DECISION DELEGATED TO HEAD OF PLANNING

Application No: H16-0514-25 **Applicant:** Tulip-Fields Homes Ltd
Proposal: Proposed Residential Development
Location: Off Chaucers Way Spalding Lincolnshire
Terminal Date: 29th July 2025

PROPOSED BLOCK PLAN

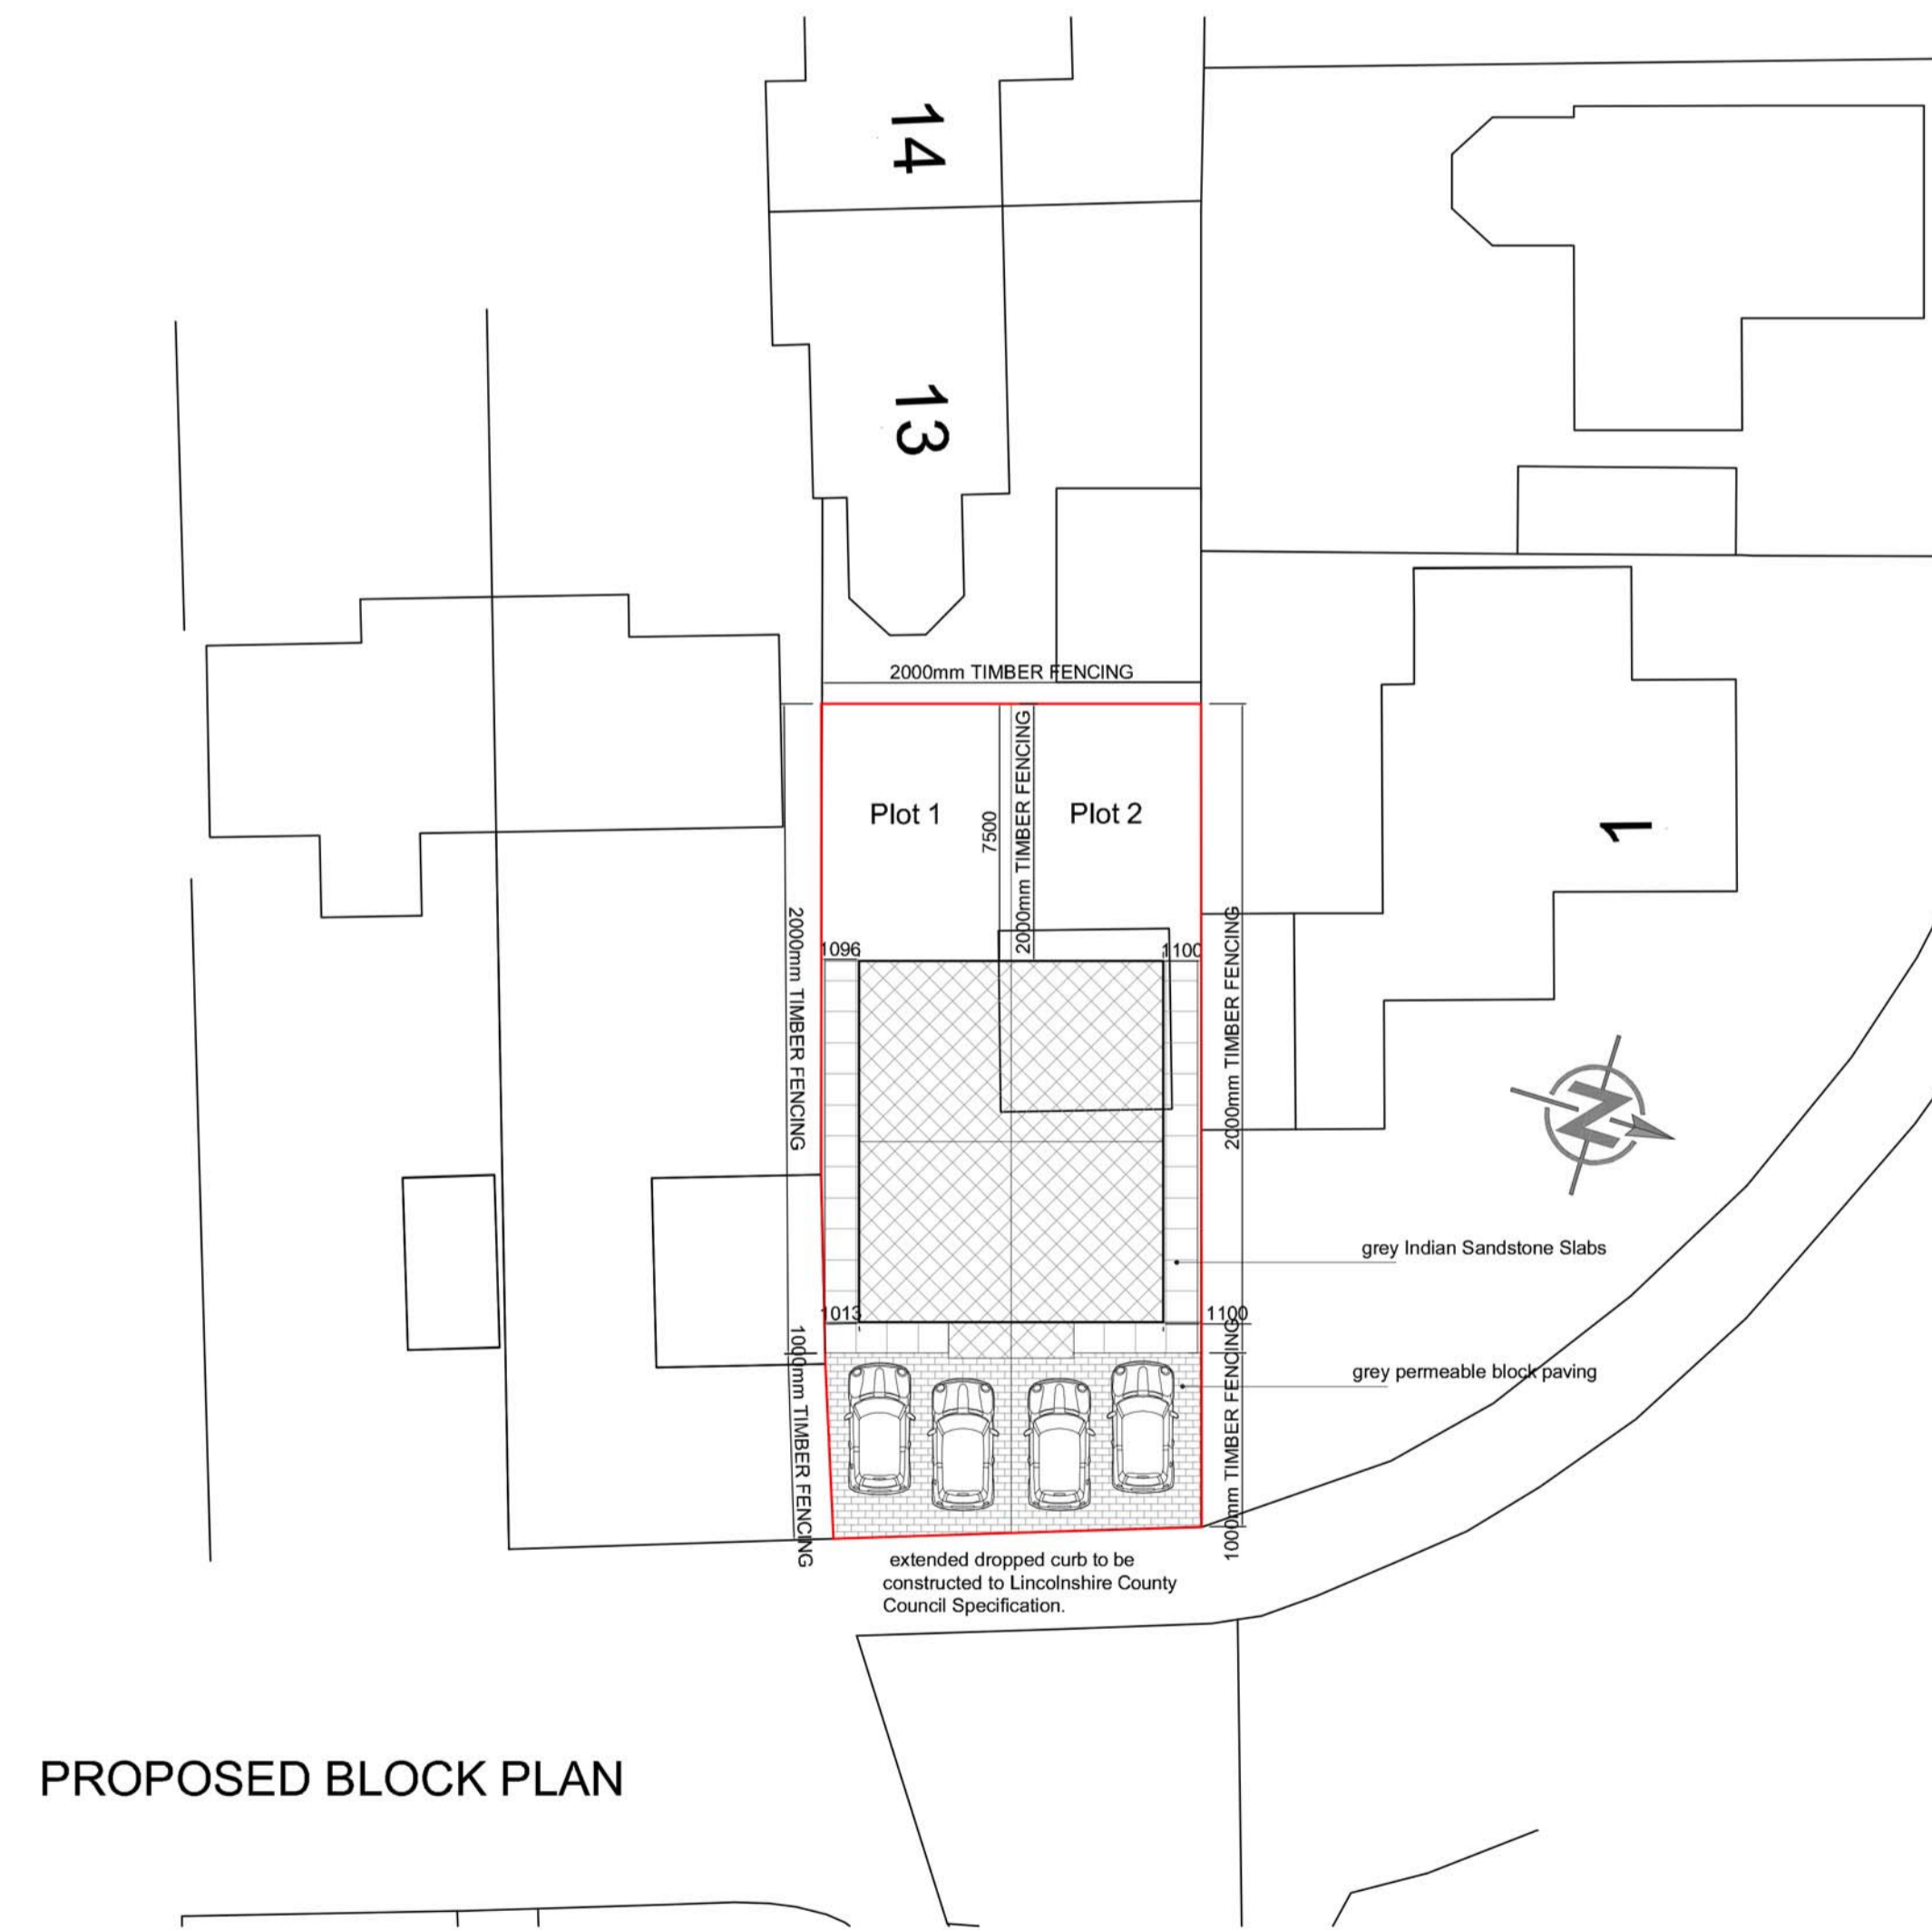
"The vehicle crossing is to be extended and a note should be added to the site plan to say it will be constructed to Lincolnshire County Council Specification.

The height of fence adjoining the highway from the front elevation of the houses is to be reduced to 600mm on the site plan to ensure visibility is maintained."

The request from the Highway Authority to add the relevant note relating to the access has been followed through, although no further comments from the Authority were subsequently received.

Turning to the fencing, The comments of the Highway Authority have been noted; however, it is not considered that they would carry significant weight against the proposal. A 1m high boundary treatment could be constructed under the provisions of Schedule 2, Part 2, Class A of the General Permitted Development Order, 2015, in this position. This would have the same effect as the development proposed here, and would be beyond the control of the Authority. Due to this significant fallback position, it is not considered appropriate to restrict the development excessively.
